RE: Existing Septic System Inspection HTE# 17-5-41737
(Old Reference to 12-5-28321)

An attempt was made to evaluate your property for the purpose of issuing an Existing Tank Permit. The evaluation could not be completed for one or more of the following reasons.

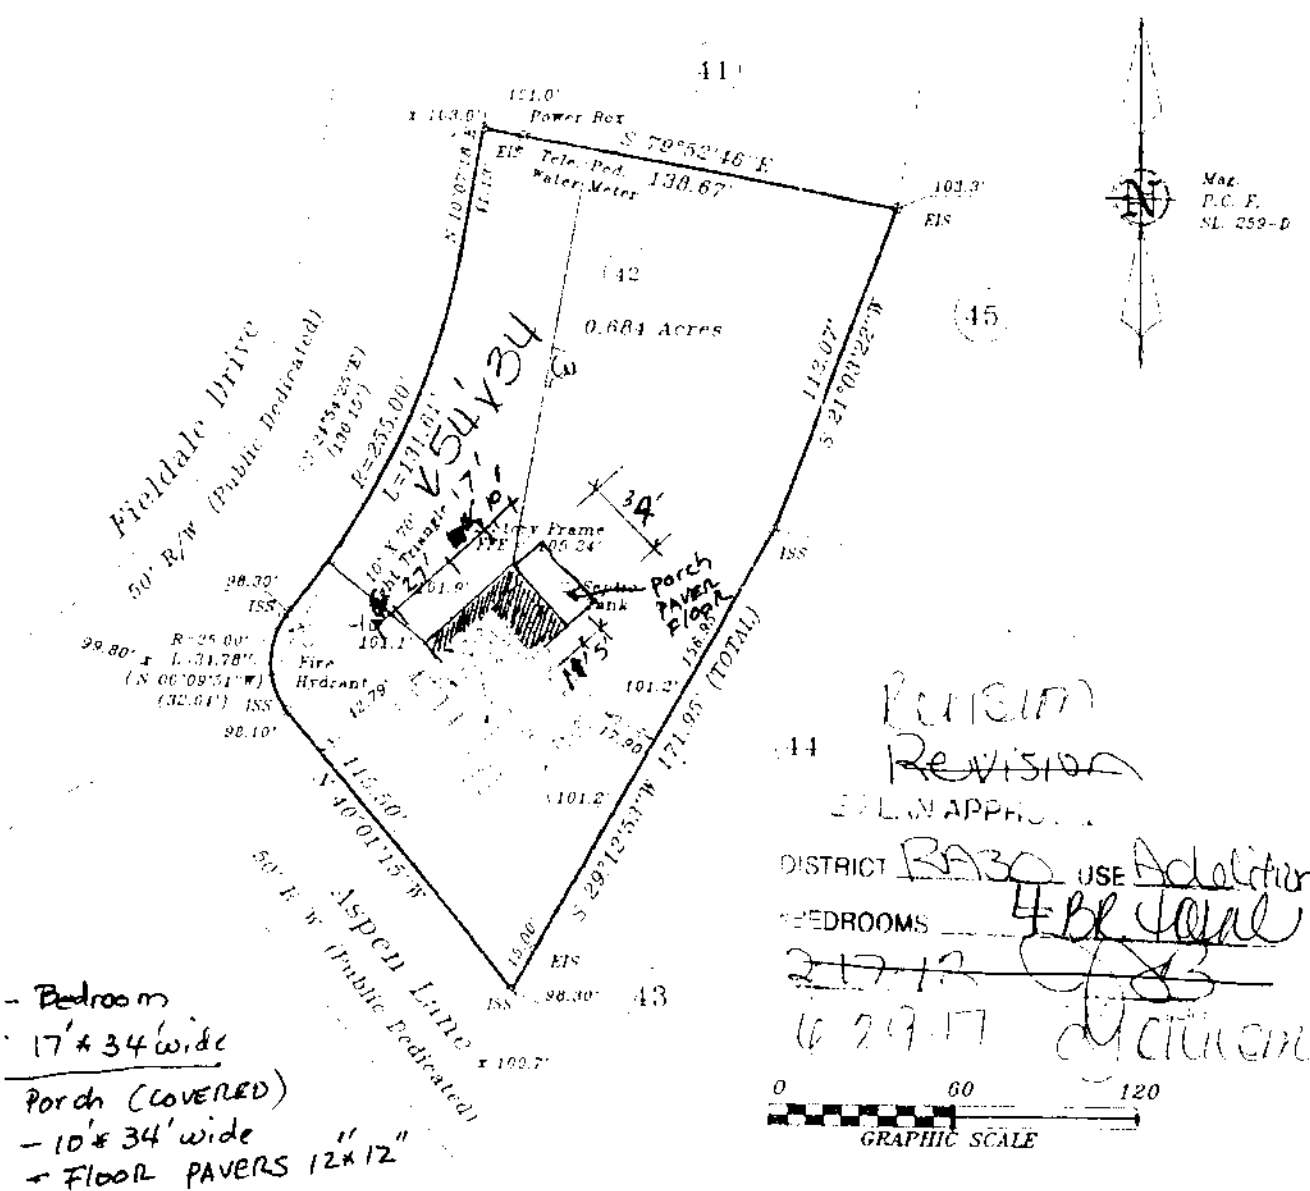
- 1. Uncover outlet lid on septic tank and break seal (*\$25.00 fee incurred*)
- 2. Have system pumped out
- 3. Replace sanitary T
- 4. **Other - Will need a soil report from a private consultant due to not enough available space. Please use correct map. Application lists lot two but site plan used was for lot 42. Please clarify and revise.**
